From:
Sent: 14 December 2022 16:40
To:
Subject: 2022/92459 Bankgate Mills, Bank Gate, Slaithwaite, Huddersfield, HD7 5DL
Attachments: 3486 (0-) 14 A _ Proposed Second Floor Site Plan.pdf; 3486 (0-) 15 A _ Proposed Third Floor Site Plan.pdf; 3486 (0-) 16 A _ Proposed Unit 1 & 2 Elevations.jpg; 3486 (0-) 18 A _ Proposed Mill Elevations.jpg; Station Road Example.zip

Please see attached revised mill building drawings in response to _____ on the 28.11.22.

Proposed Second Floor Plan - 1:100

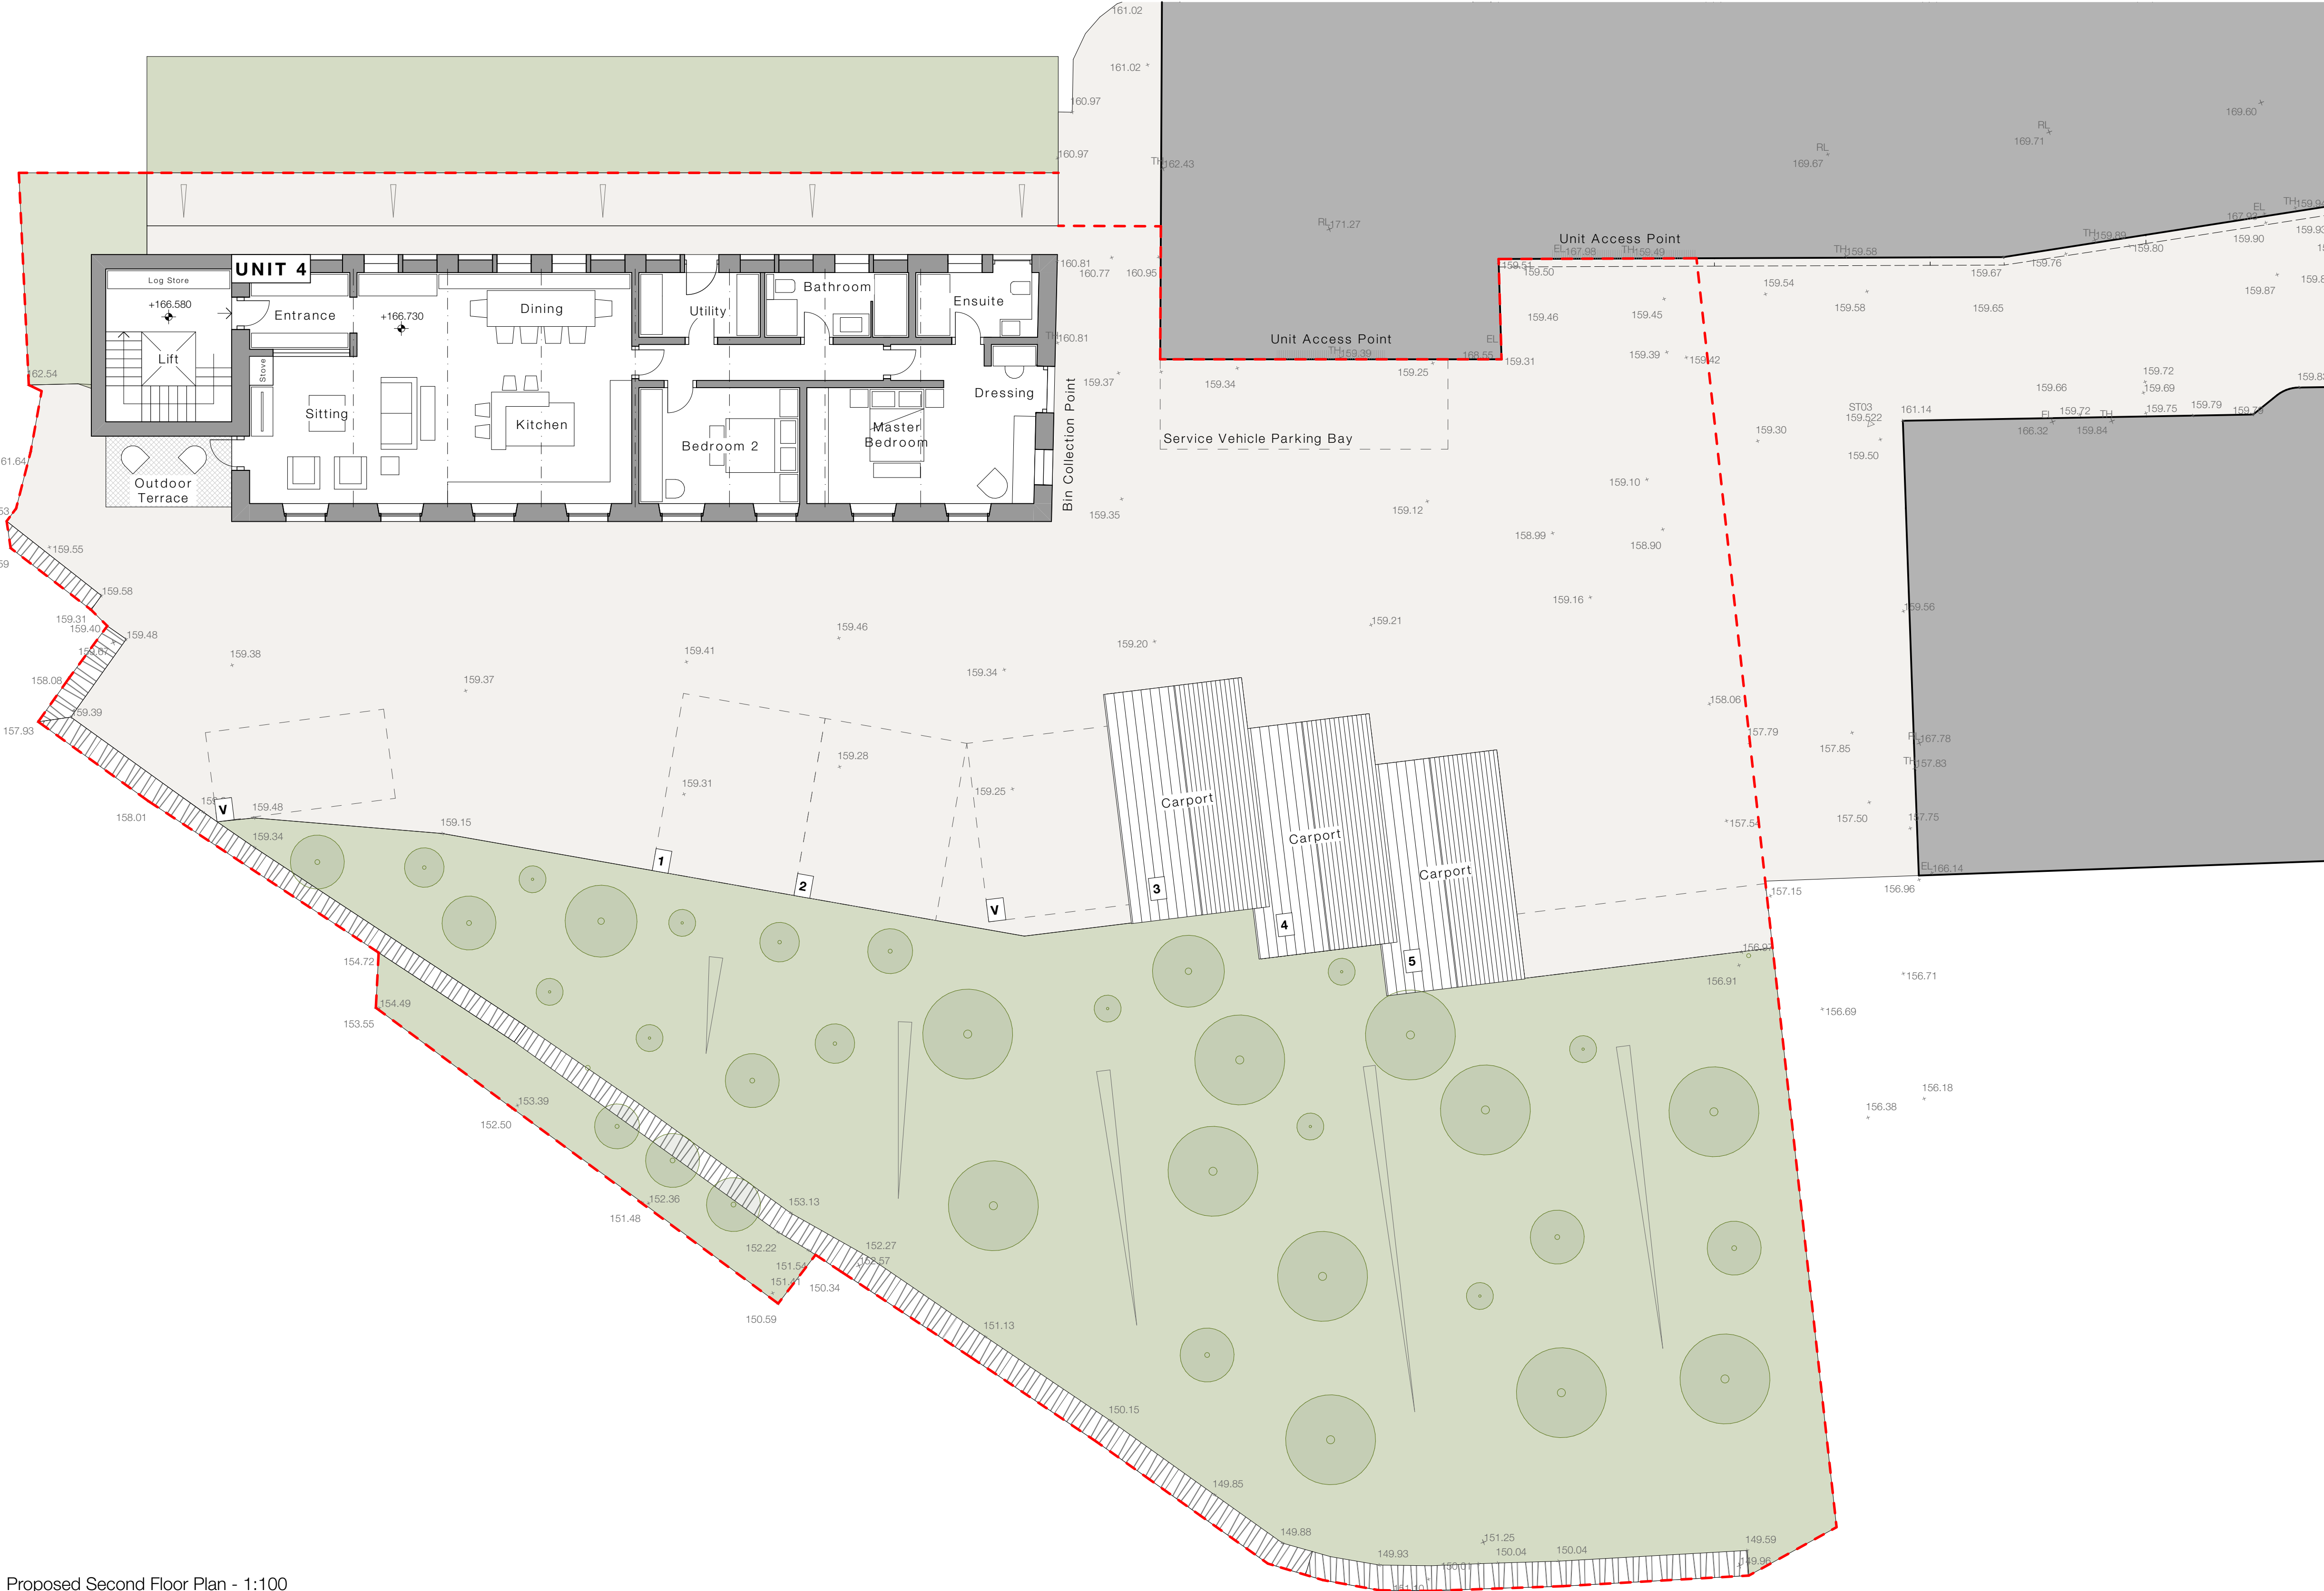
- The timber loading doors to the east elevation have been reinstated. The historic joist will also been retained both internally and externally.
- Internally, the top 3 floor plans have been designed to be as open plan as possible. All internal walls and spaces have been designed as to not impact on existing window openings. Due to ease of access, and the need for a mix of unit types, the ground floor lends itself to be split into 2 apartments.
